<b>Submission No.</b>			<b>130</b>	
<b>Organisation Name or Name of Submitter</b>			<b>Irish Life Assurance plc. (4 Earlsfort Terrace) - represented by Waterman Moylan</b>	
<b>Item No.</b>	<b>Section Ref.</b>	<b>Page No.</b>	<b>Observation Statement</b>	<b>TII Response</b>
<b>Re: Railway (Metrolink-Estuary to Charlemont via Dublin Airport) Order 2022, 4 Earlsfort Terrace Dublin 2 (Formerly known as Dolman House)</b>				
1	Submission 1	3	<p>The route selection, including horizontal alignment, vertical alignment and depth of MetroLink below ground in the area between Chainage 18+800 and Chainage 18+900, should be reviewed by NTA / TII to satisfy themselves and to ensure that (a) MetroLink does not cause structural damage to the foundation system supporting our client's building.</p> <p>(b) MetroLink does not cause structural damage to our client's building at the basement level, any damage would result in the ingress of water into the basement.</p> <p>(c) MetroLink does not cause damage to the cladding; glazing and fragile finishes of our client's building.</p> <p>(d) MetroLink provides the necessary vertical and/or horizontal clearance between the existing basements and the tunnels.

Drawing Status	FINAL	
Scale @ A3	1:10,000	DO NOT SCALE
JACOBS No.	32108600	
Client No.		
Drawing No.	ML1-JAI-EIA-ROUT_XX-DR-Y-14009	Rev P02

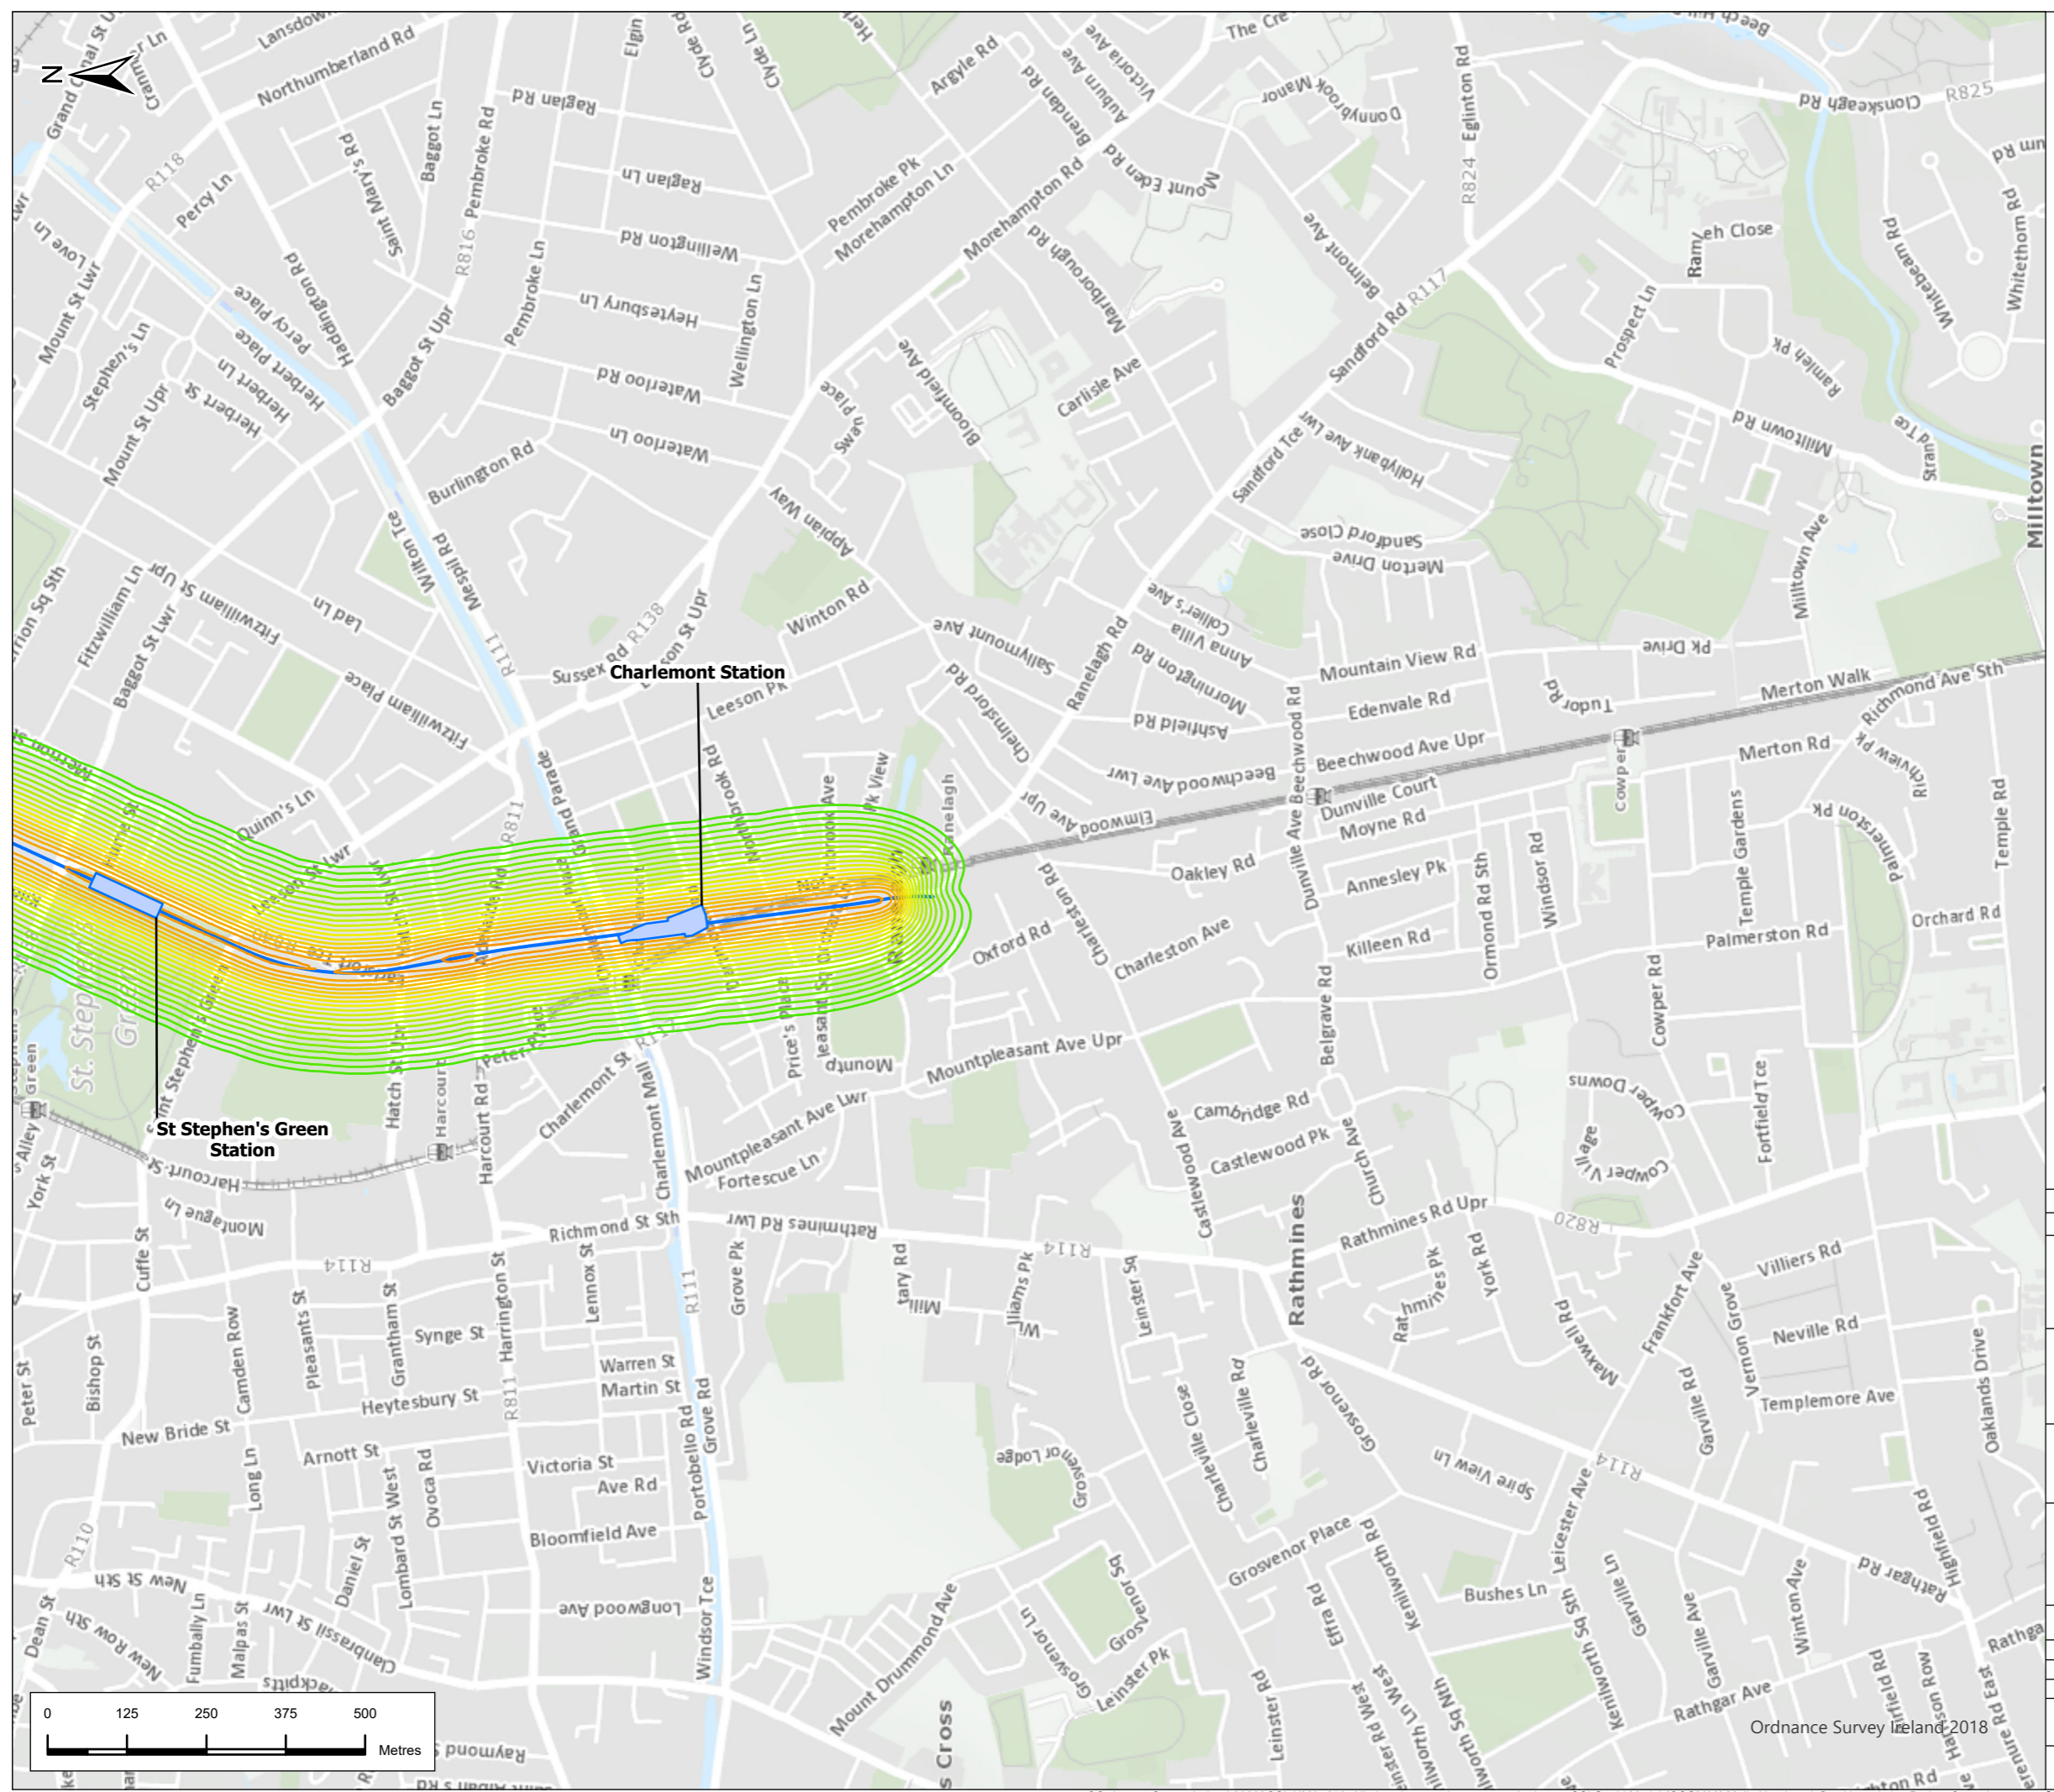
2	Submission 2	3	<p>a) Metrolink has assessed the "Groundborne Noise from Tunnel Boring Machine" and presents its findings on drawing no. ML1-JAI-EIA-ROUT-XX-DR-Y-14009 (a copy is attached to this submission). This drawing indicates MetroLink will generate an additional 45db directly under the location of our client's building which is unacceptable.</p>	<p>Appendix 14.5 Groundborne Noise and Vibration Blasting Modelling Results presents predicted groundborne noise and vibration levels during the construction and operation phase of the project. The prediction of groundborne noise during TBM passage for the 4 Earlsfort Terrace building is 46 dB LASmax, which is slightly above the 45 dB LASmax threshold, resulting a significant impact on the building for the limited duration of TBM passage (less than 2 weeks). This level of noise will be noticeable for the short duration of time when the TBM is underneath the building but will not cause any structural damage to the building.</p> <p>The principal mitigation measures referenced in EIA Appendix 5.1 aimed at minimising impacts are as follows:</p> <ul style="list-style-type: none"> <li>- Advance public consultation and stakeholder engagement can greatly reduce the significance of groundborne noise effects, as building occupants would be prepared for the passage of the TBM and resultant elevated noise and vibration levels.</li> <li>- TII will accept and consider applications for additional measures on a case-by case basis, in accordance with its Noise and Vibration Mitigation Policy (see EIA Appendix A14.6, Airborne Noise &amp; Groundborne Noise Mitigation Policy).</li> </ul>
